# CITY OF ALBUQUERQUE

September 11, 2020

**Re: Being There Duplex  
1315 Mountain Rd NW  
30-Day Temporary Certificate of Occupancy  
Transportation Development Final Inspection  
Engineer's/Architect's Stamp dated 5-21-19 (J13D210)  
Certification dated 8-28-20**

TCL-1

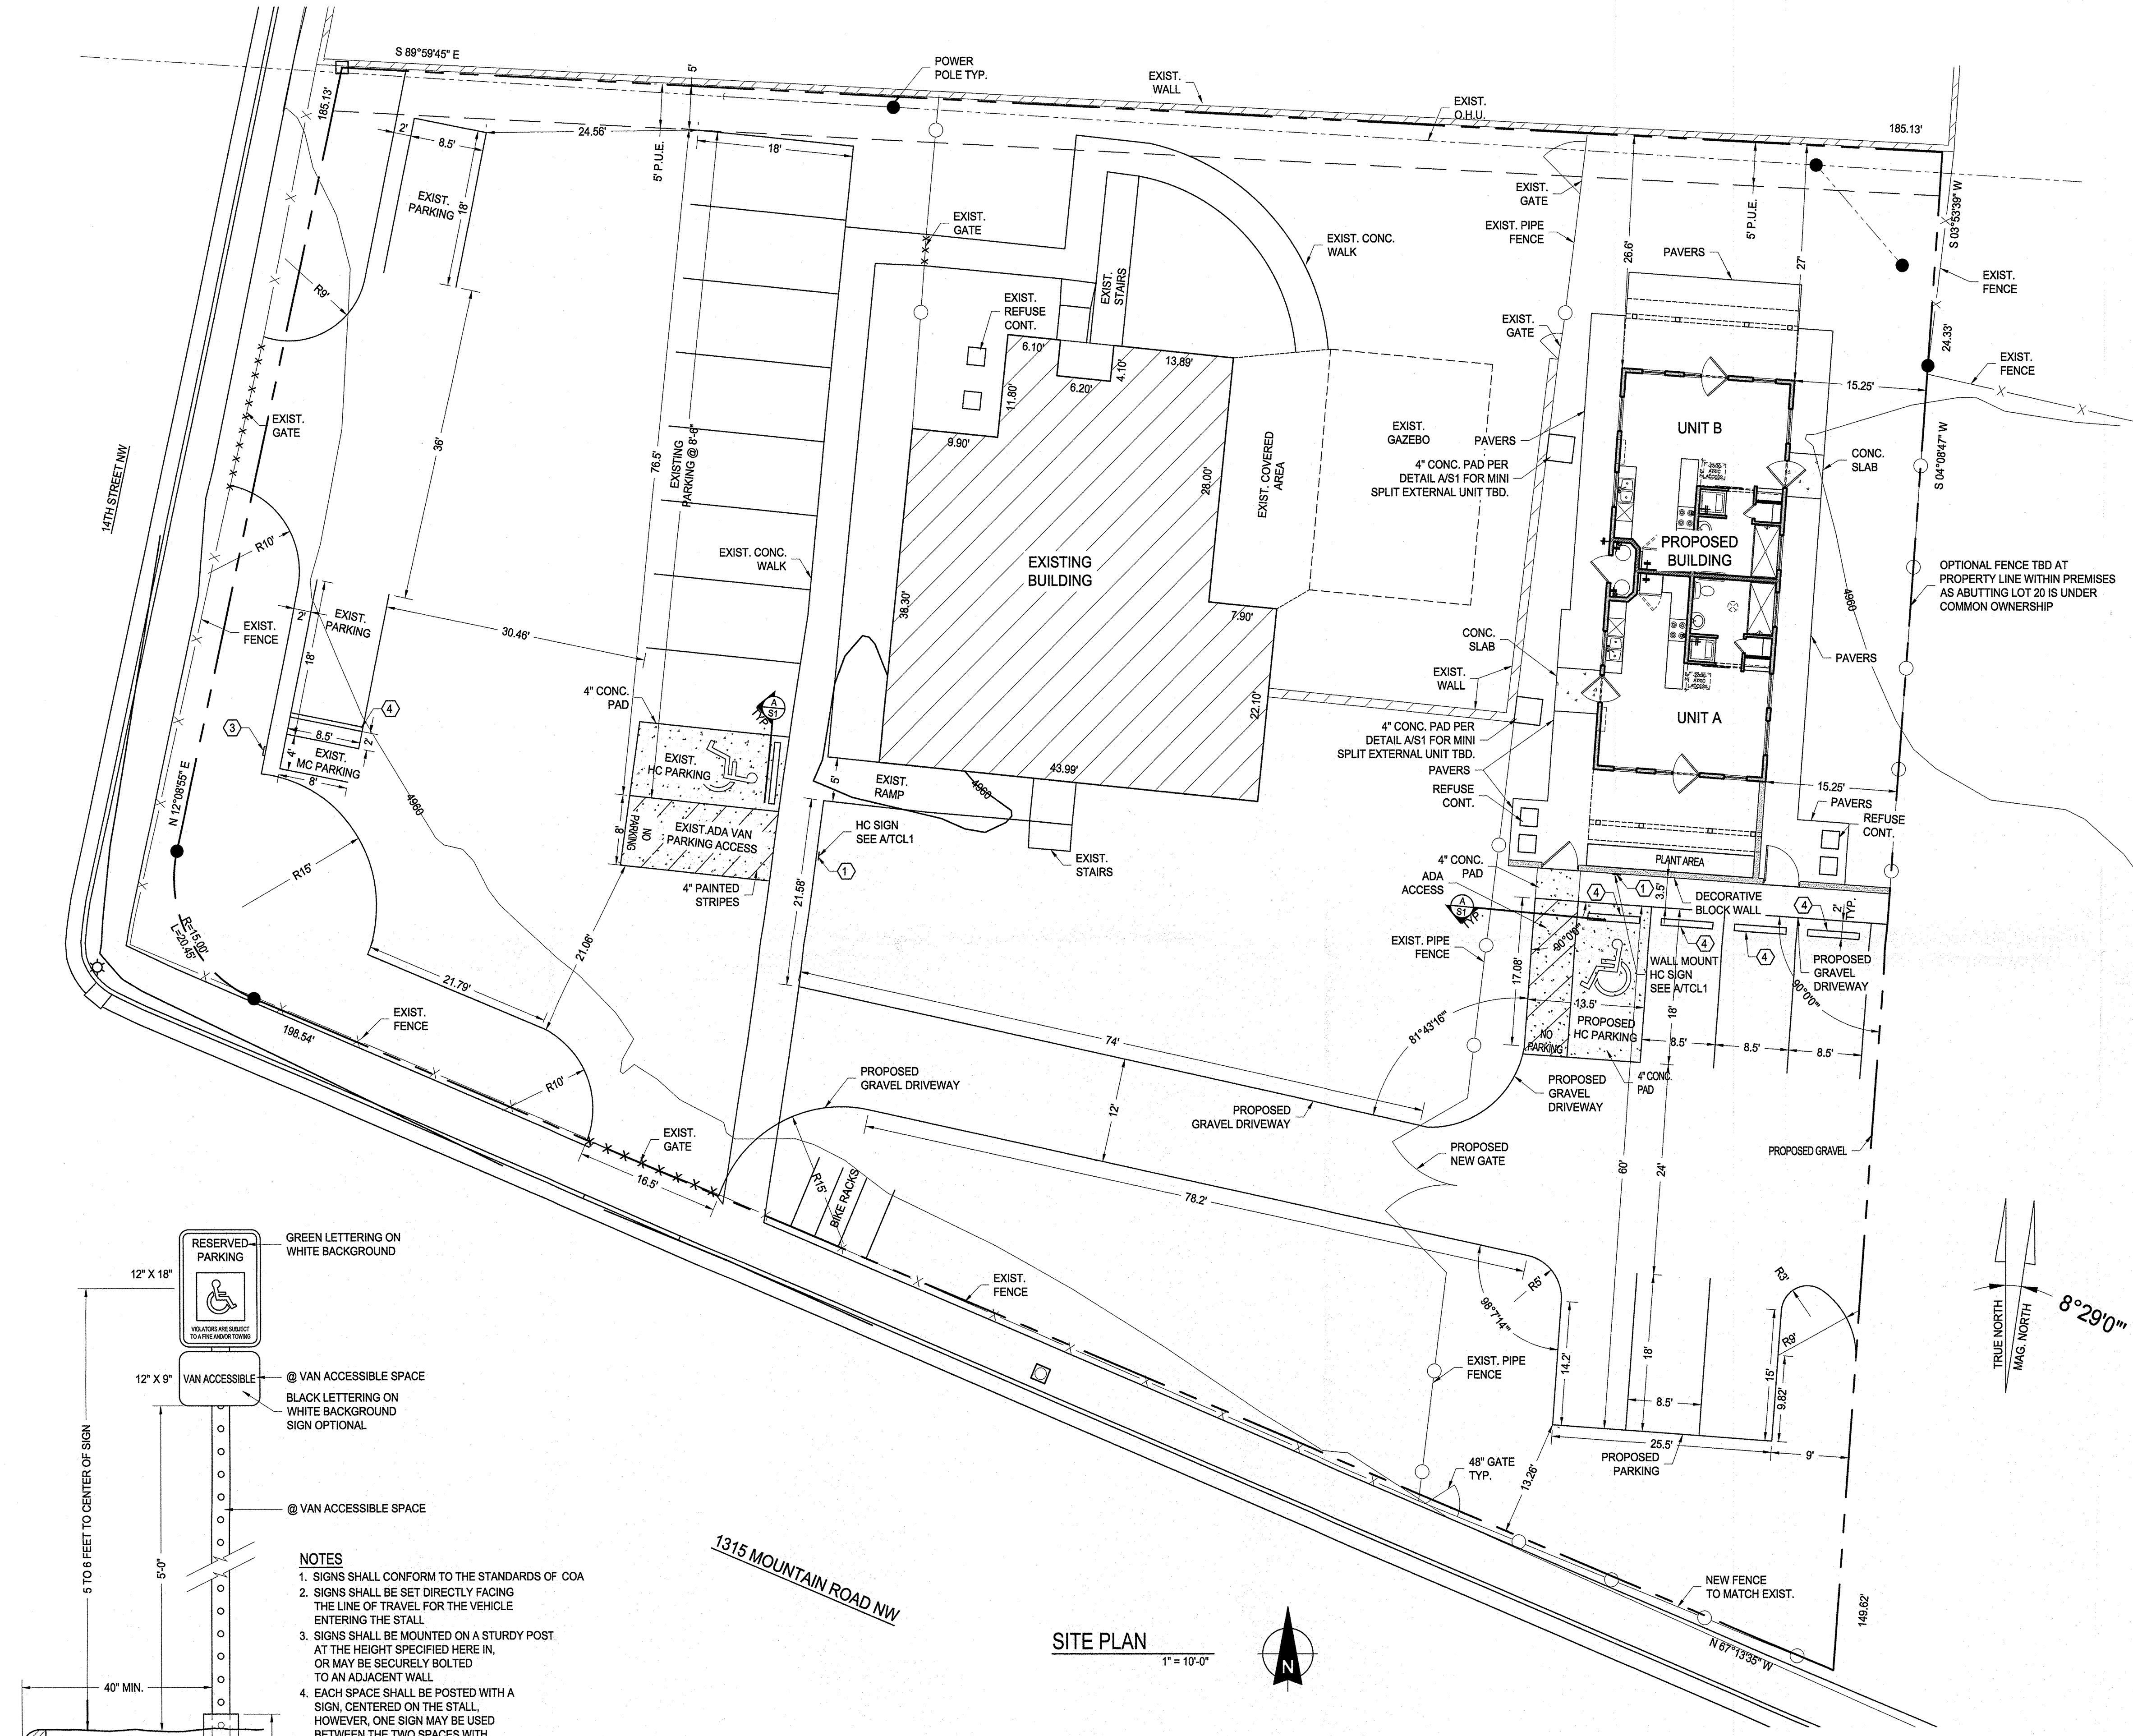
- The ADA access aisle shall have the words "**NO PARKING**" in capital letters, each of which shall be at least one foot high and at least two inches wide, placed at the rear of the parking space so as to be close to where an adjacent vehicle's rear tire would be placed. (66-1-4.1.B NMSA 1978)
